WEST SUSSEX COUNTY COUNCIL CONSULTATION

TO:	Arun District Council FAO: Andrew Wood
FROM:	WSCC - Highways Authority
DATE:	12 March 2019
LOCATION:	Quiet Waters Roundstone Lane Angmering BN16 4AX
SUBJECT:	A/28/19/PL Variation of condition 1 imposed under A/81/18/RES relating to approved plans for site layout plan, apartment block floor plans, elevations & roof plans & materials layout.
DATE OF SITE VISIT:	
RECOMMENDATION:	Advice
S106 CONTRIBUTION TOTAL:	N/A

Project. Angmering		
Title. Proposed site Layout		
Construction		
Scales. 1:200@A1		Date. May 2018
Drawing Number. 1006-Ang101	Revision. R	Drawn by. PM

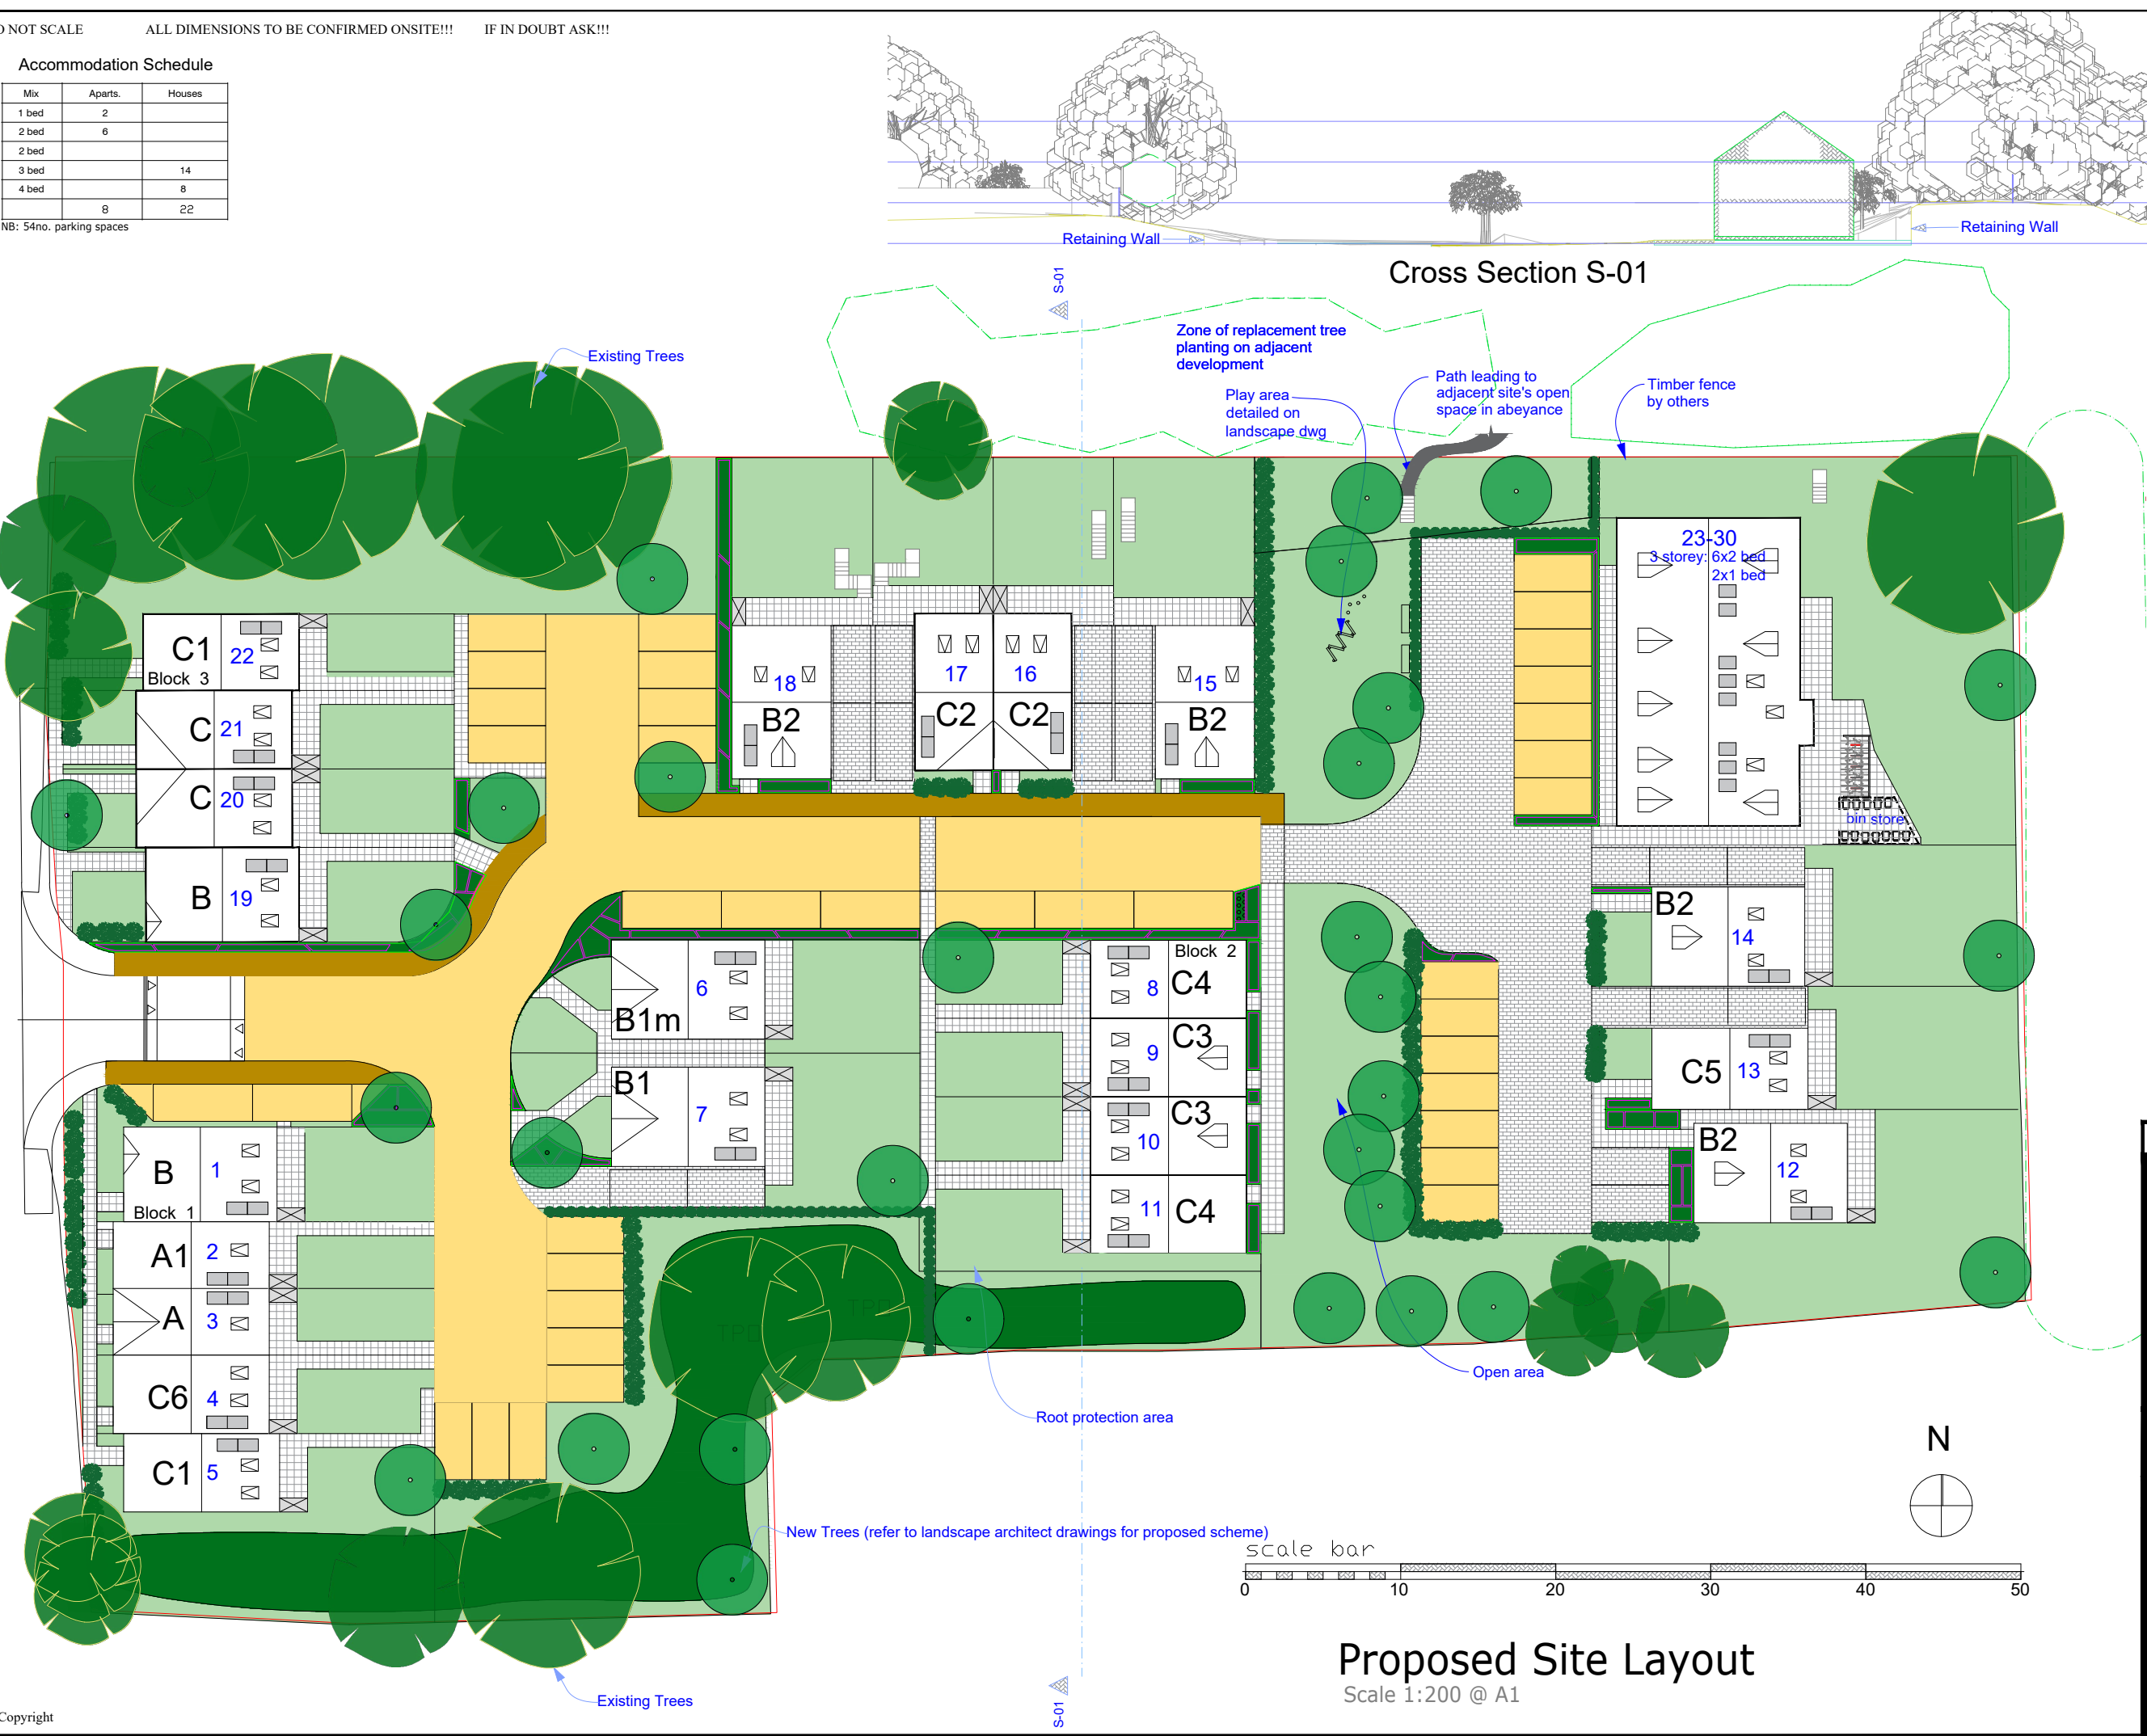
- Kerb realigned-The kerb has been re-aligned on the access road between Plots 19 and 6. The LHA have reviewed the drawing provided in support of this application and are satisfied with the re-aligned footway.
- Footpath Along Frontage-It is indicated that an area of footpath has been included however from an inspection of the plans no official dimensions of the proposed footway have been provided. This should be constructed in line with Manual for Streets (MfS) parameters with a minimum footway width of 1.5 metres. Some additional clarity on this point in form of a revised plan should be provided at the Stage 2 Detailed Design stage of the application. The Stage 1 Road Safety (RSA) would have considered the footway as part of the Audit.
- Turning Area for Plot 12-the road has been extended by 500 mm this will allow additional space for a vehicle turning.

The LHA would not raise any concerns with the proposed amendments.
